Development Facilitation Team (DFT) – Review Comments

Project No: PR-2024-010457 Date: 6/26/2024 Agenda Item: #5 Zone Atlas Page: J-11

Application For: SD-2024-00103 – PRELIMINARY/FINAL PLAT

DRB Project Number: 2024-010457
600 Coors NW

Plat for
Lots C-1 and C-2, Block J
Northern Heights
Being Comprised of
Lot "C" and Southerly Portion of
A Vacated Alley, Block J
Northern Heights
City of Albuquerque
Bernalillo County, New Mexico
March 2024

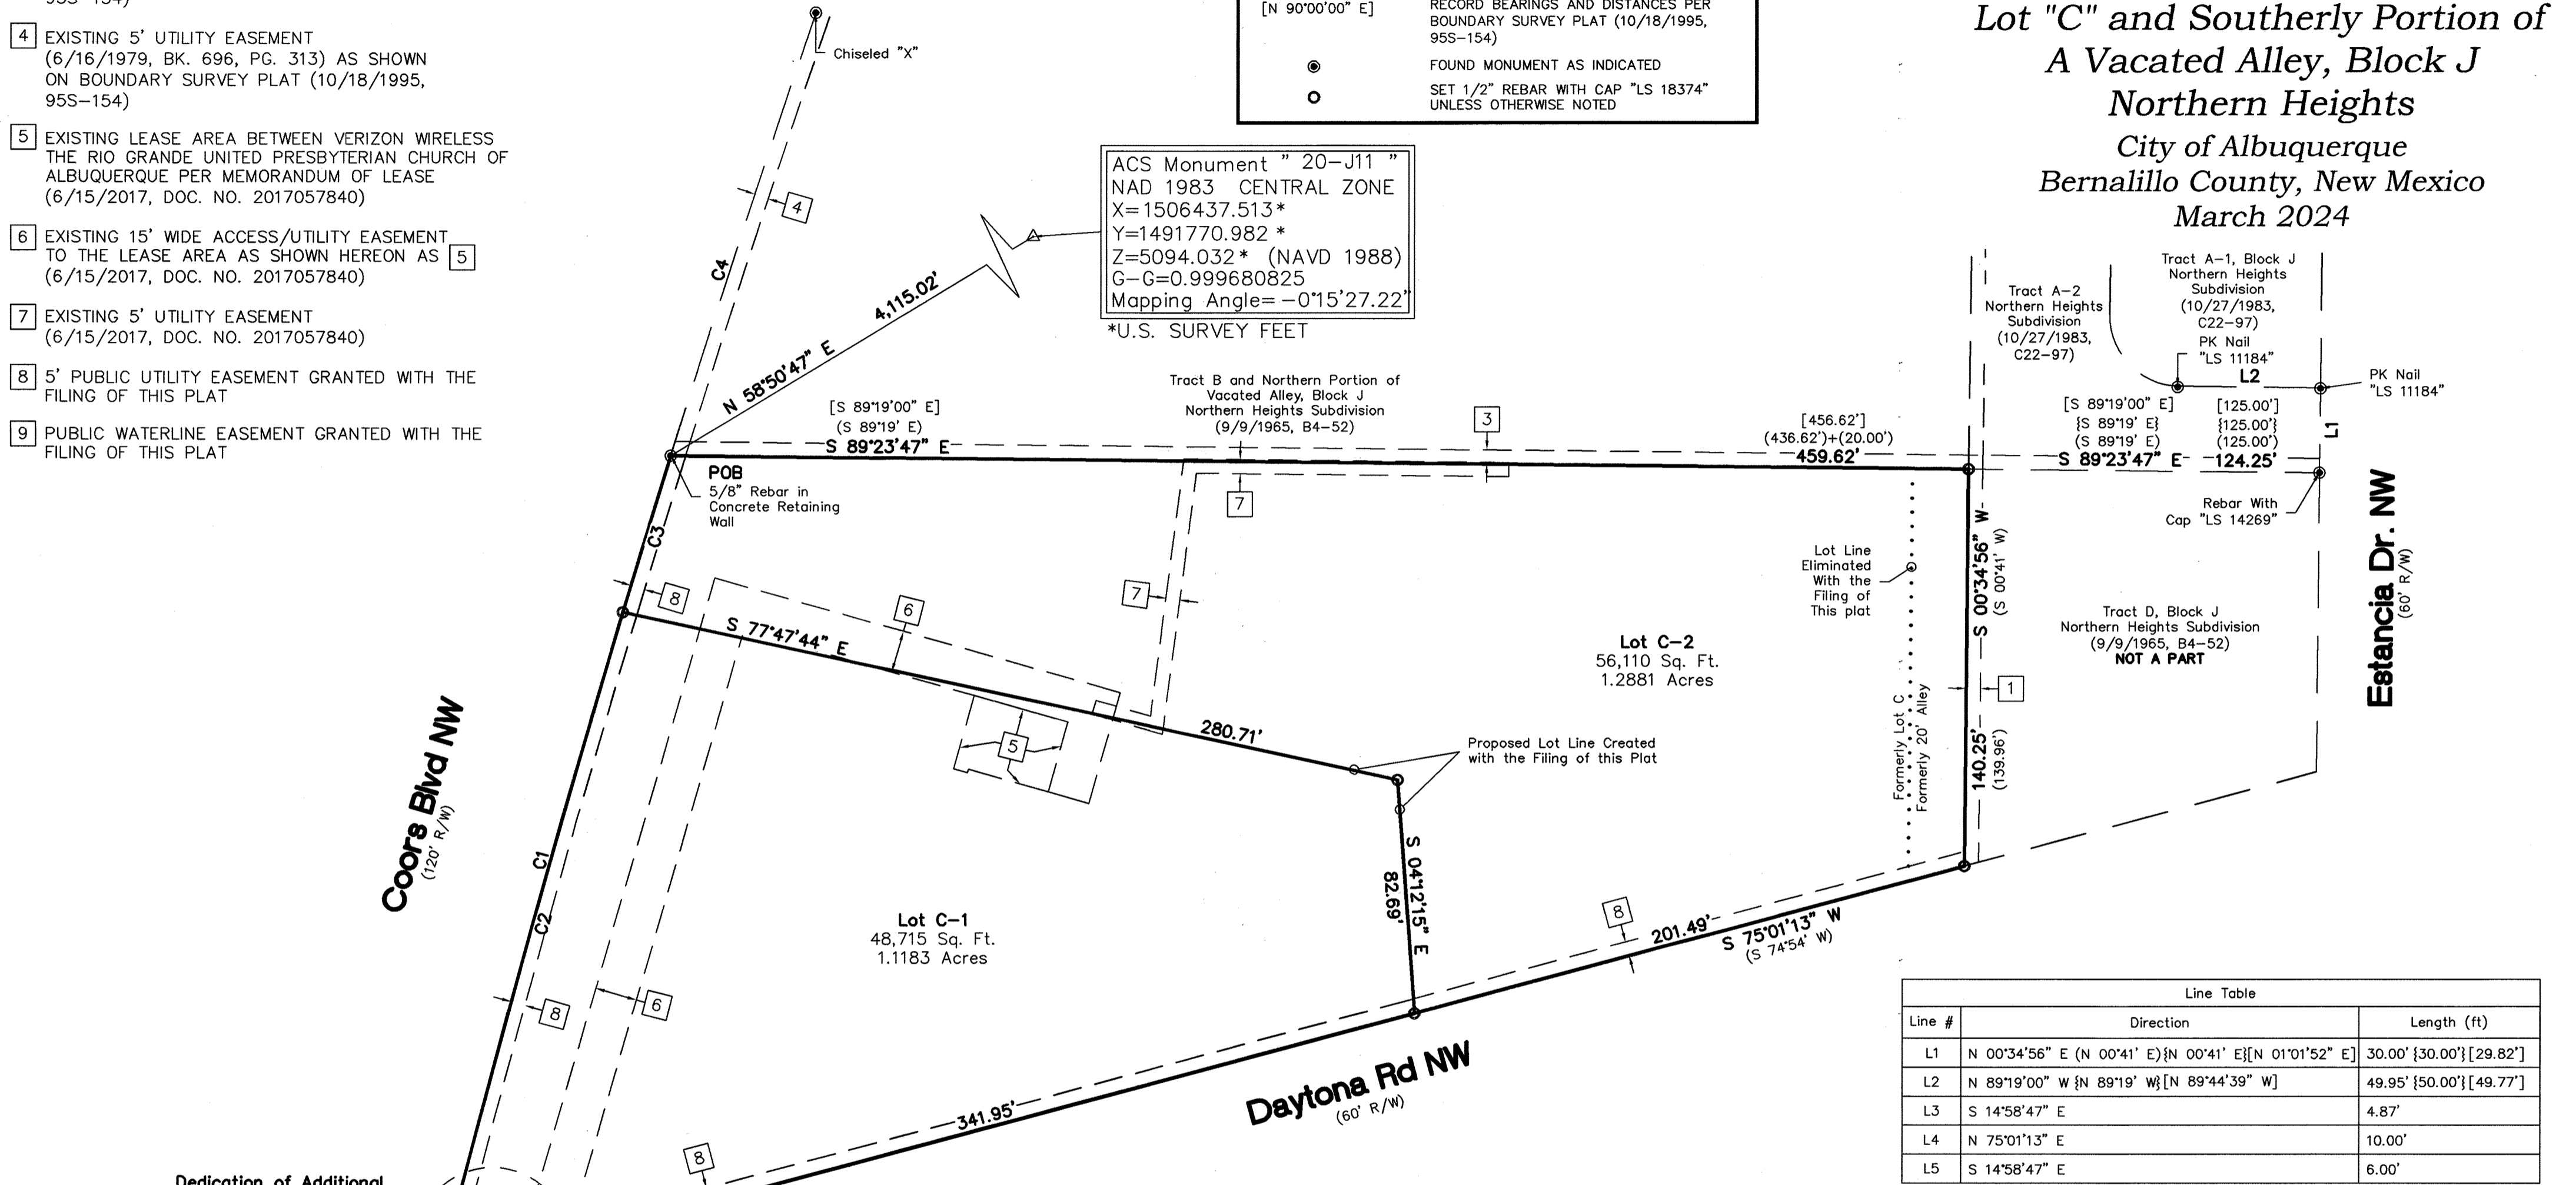
1. Coors is a Principal Arterial and a Major Transit Corridor. Daytona is a local road. Existing sidewalks along both roadways meet requirements listed in the DPM.
2. Please provide ROW dedication at the intersection to keep sidewalk within ROW. Currently the property line clips the sidewalk at this intersection.
3. For future development an approved TCL will be required prior to site plan or building permit. Also, a Traffic Scoping form will need to be filled out and submitted to Curtis Cherne (ccherne@cabq.gov) to determine if a TIS will be required.

****Verification of standards per Transportation****
Coors is a Principal Arterial and a Major Transit Corridor. Daytona is a local road. Existing sidewalks along both roadways meet requirements listed in the DPM.
Please provide ROW dedication at the intersection to keep sidewalk within ROW. Currently the property line clips the sidewalk at this intersection.

**Plat for
Lots C-1 and C-2, Block J
Northern Heights
Being Comprised of
Lot "C" and Southerly Portion of
A Vacated Alley, Block J
Northern Heights
City of Albuquerque
Bernalillo County, New Mexico
March 2024**

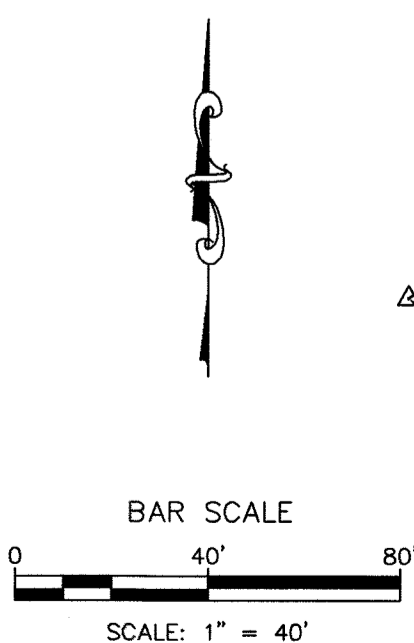
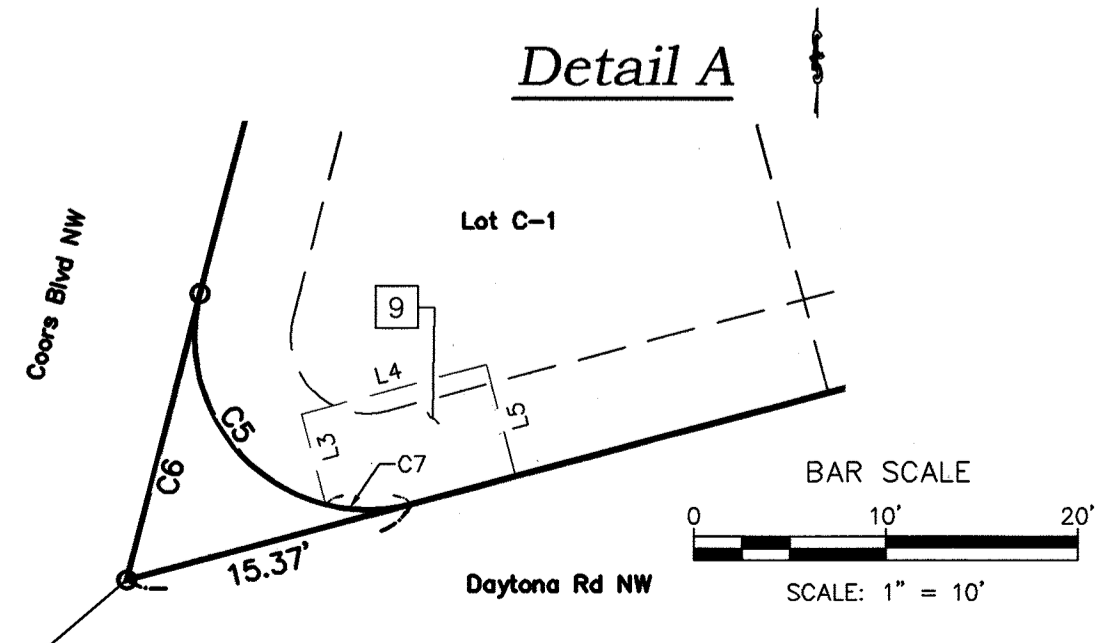
1. No objection. However, please add the following note to the plat:
 - a. “Existing public water and/or sanitary sewer infrastructure may not be constructed or sized to adequately serve potential future development. Improvement or upsizing of existing public infrastructure may be required as a condition of future development approval.”
